RE: State Significant Development Application SSD-92743706 at 706-752 Mamre Road, Kemps Creek (AirTrunk)

Mamre Road Data Centre Campus

Attachment 2 – Stormwater Comments

Figure 8: Catchment extents under proposed conditions

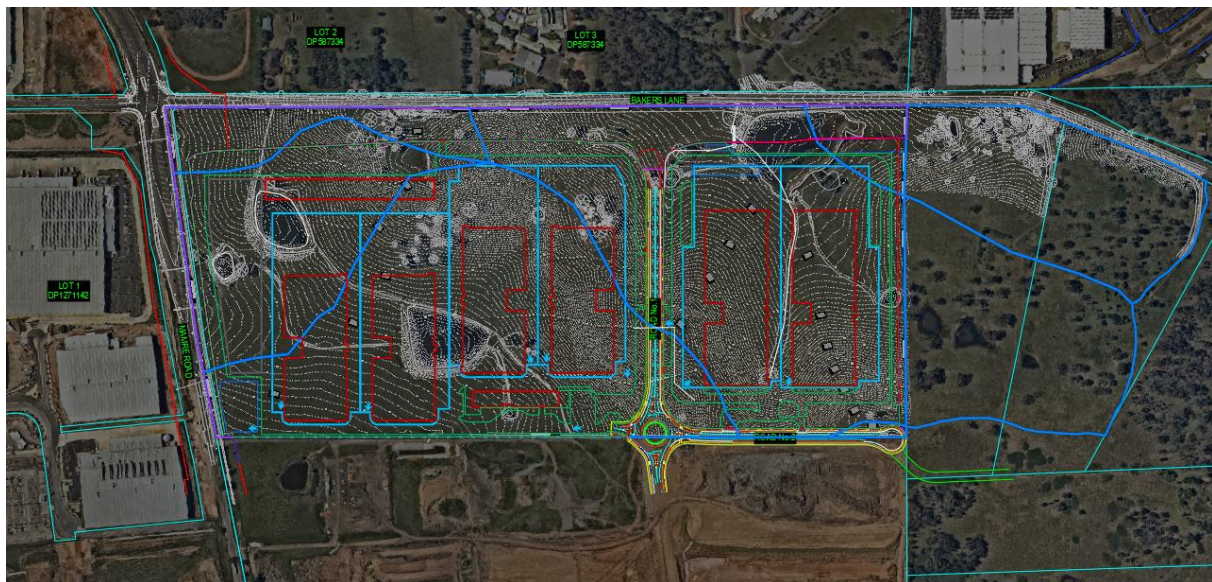
- WSMP Figure 8: Add parcel numbering to figure for clarity and ensure it aligns with numbering used in the Civil Works Package. Please also add catchment areas (in ha), change in catchment areas (pre- versus post-development), and show associated OSDs/discharge points clearly. Ensure this figure aligns with catchment plans shown in the Civil Works Package.

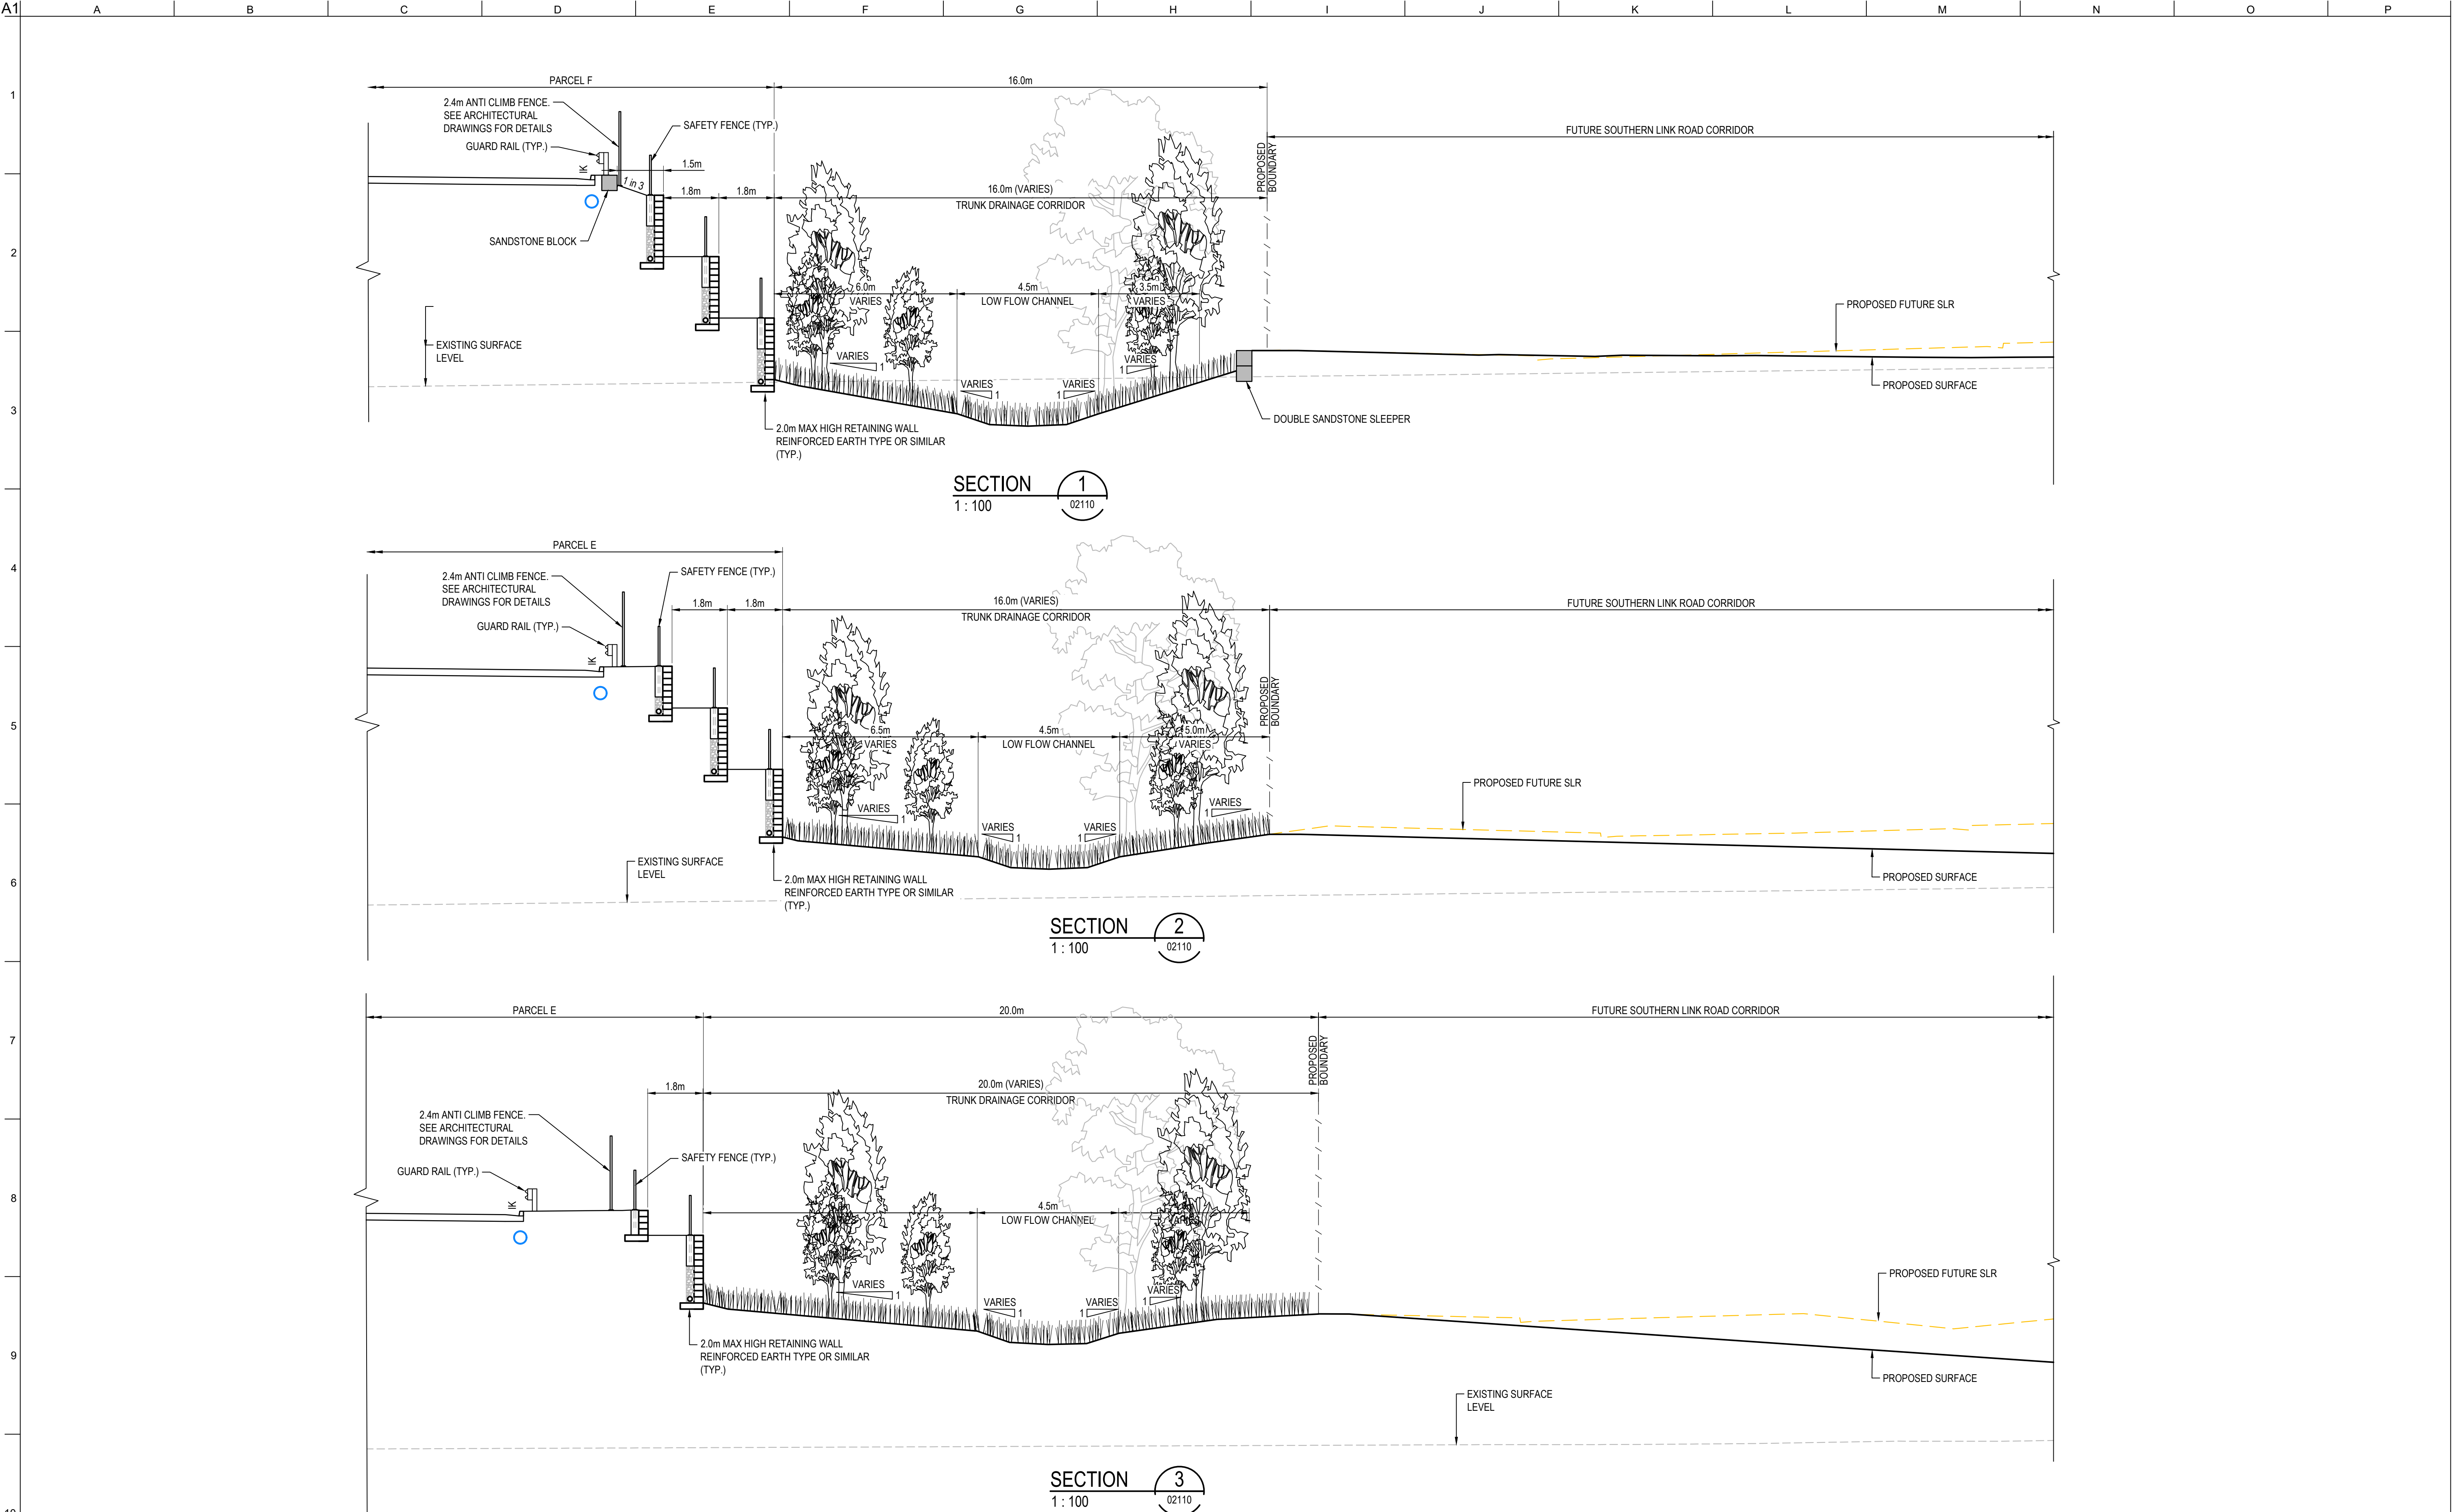
- WSMP states channel width is 15.5 – 19.5m, whereas CIV-02110 shows channel widths between 16.0 – 20.0m. Please clarify and align.
- Section 7.1 of the WSMP states ‘...hydrological and hydraulic modelling of channel flow will need to be undertaken to simulate post-development conditions for a range of design storm events...’. Please clarify if this is different to the modelling done in the existing FIRA.
- Trunk drainage landscaping plan, cross sections with water levels (minor event and 1% AEP + freeboard), solar access assessment, planform, drop structure modelling / details, and irrigation to be confirmed during detail design.

- Show A-27 and A-28 of the pit/pipe system (which continues from CIV-02041) clearly and provide annotations to show how they connect into the trunk drainage channel. Ensure this aligns with the longitudinal section on CIV-02123.

- Connection between trunk drainage channel and outlet settling forebay has been changed from 3 x 750 x 750 RC box culverts to an outlet swale. Please justify the change and provide dimensions or a cross section/detail for the outlet swale.

SECTION 4
1 : 100

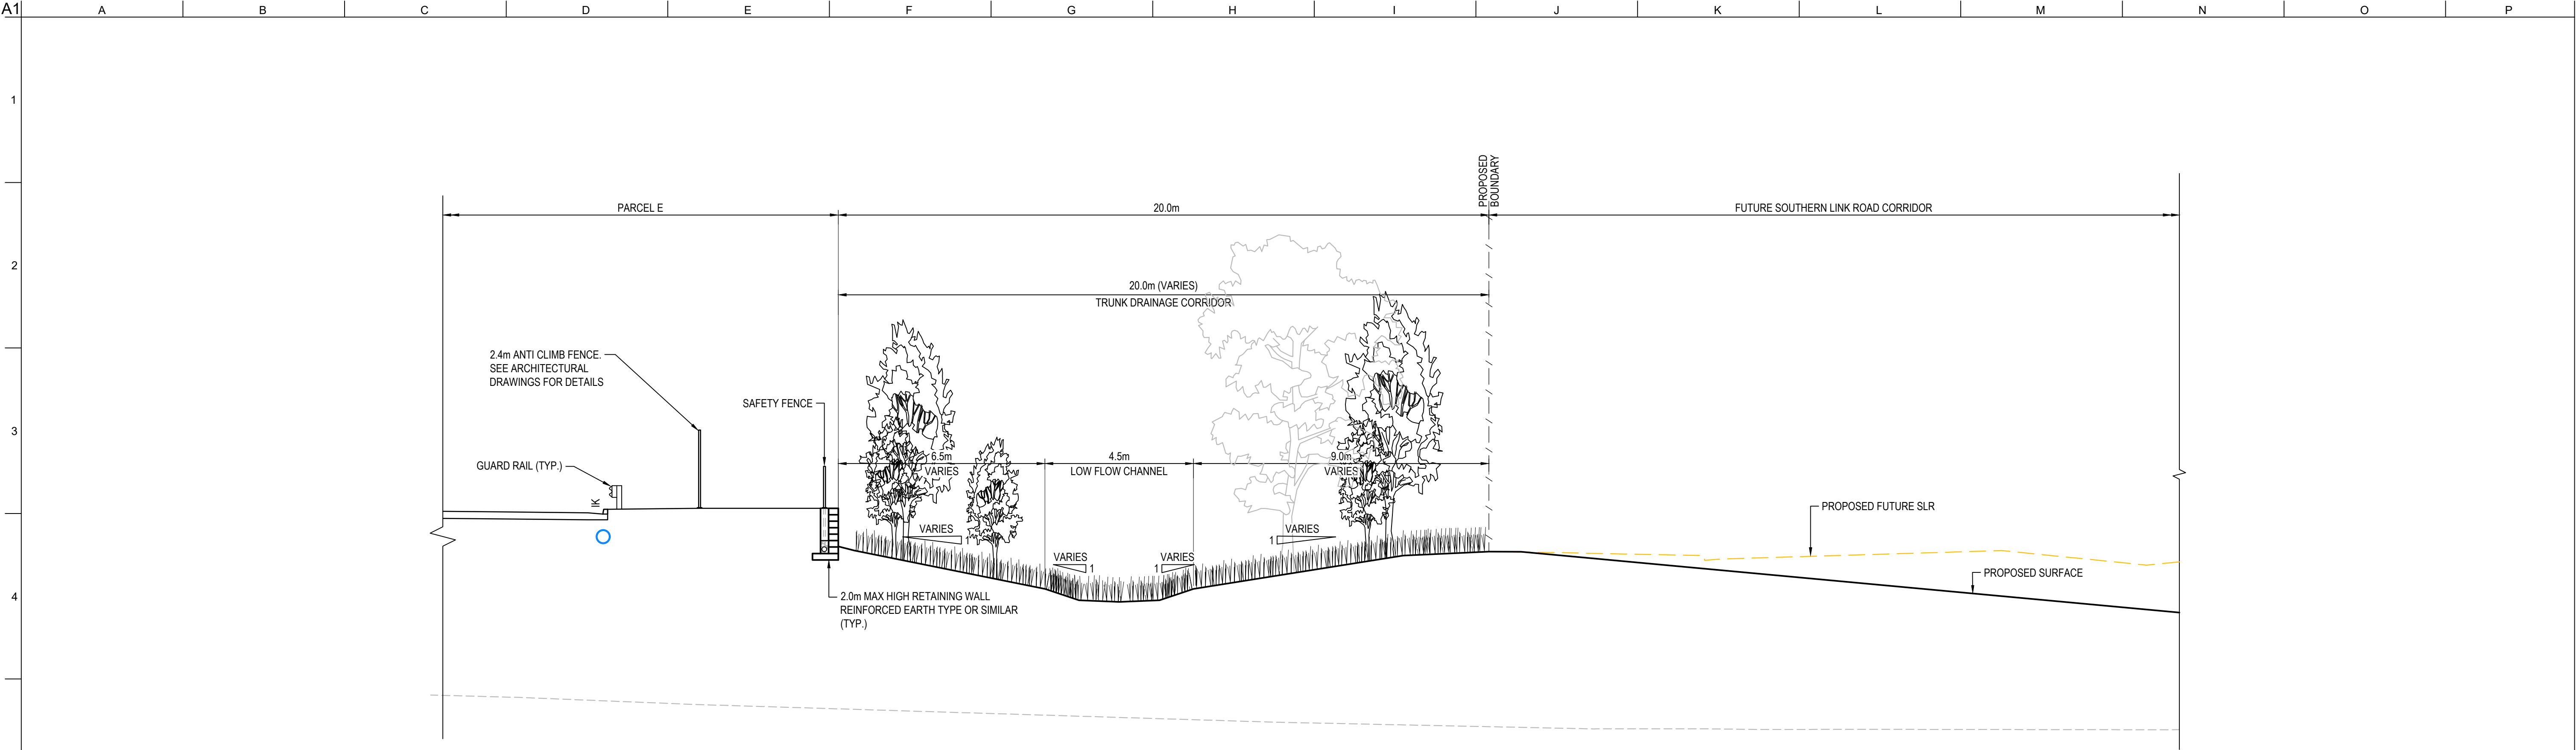
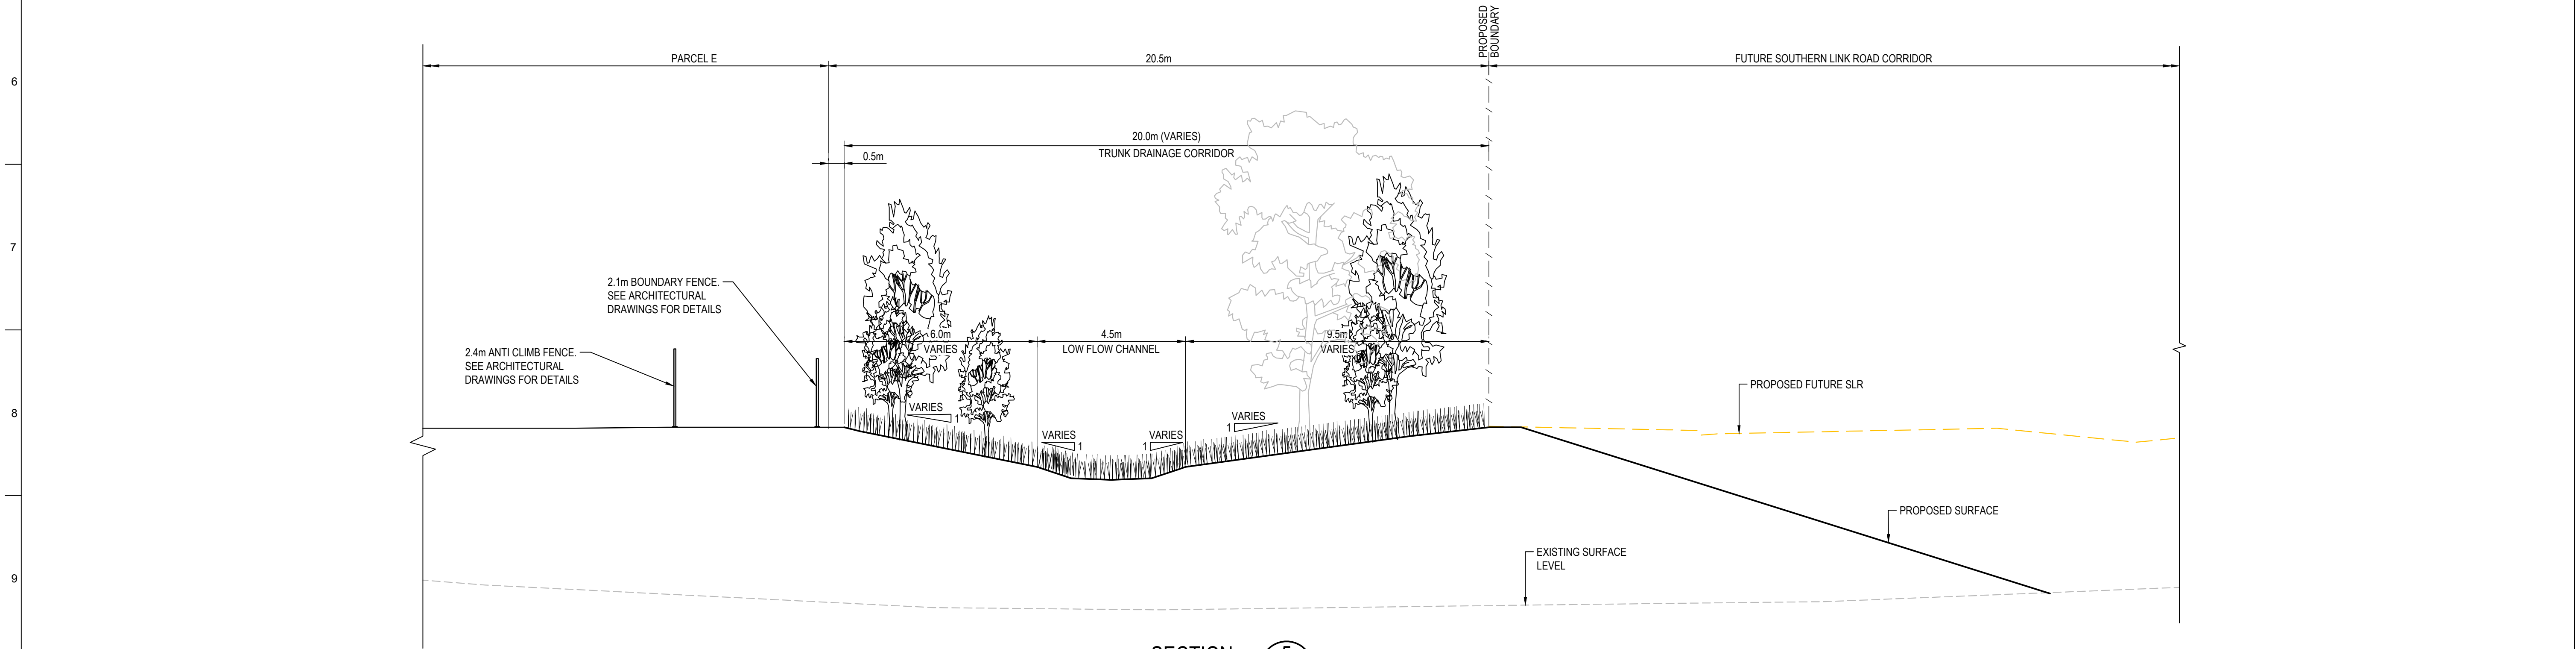
- Sandstone retaining wall is shown on the plan view drawing at Sections 4 and 5, but not shown in the sections on CIV-02112. Please align.
- Civil Works Package CIV-02111 and CIV-02112 (Trunk Drainage Channel Typical Sections):

- Indicate where Sydney Water can access the trunk drainage channel for maintenance. Please also provide dimensions of the maintenance access path.
- Provide FFLs of parcels in all sections.
